## Active Travel England Planning Response Detailed Response to an Application for Planning Permission

**Application Ref:** F/15/24/RES

**Site Address:** Land at Ford Airfield, Ford

**ATE Reference:** ATE/24/01154/RM

### **Cycle Crossings**

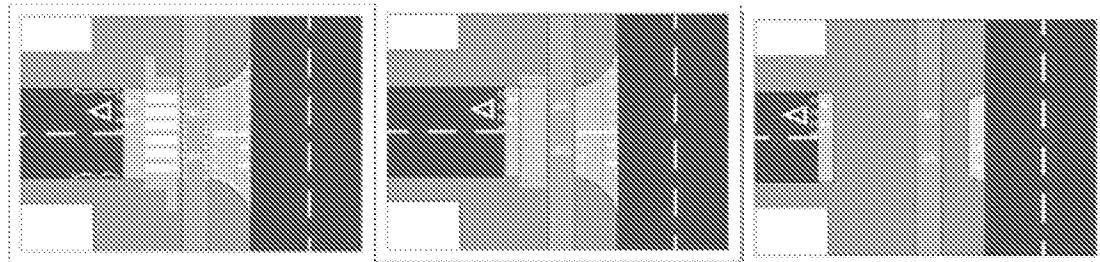
- It is noted that cycle crossings will be designed in accordance with LTN 1/20
- It is noted that provision has been made to safeguard future links and this is welcome
- It is noted that each home will have access to good quality cycle parking; note it is expected that this will be secure, covered and accessible without taking cycles through the home
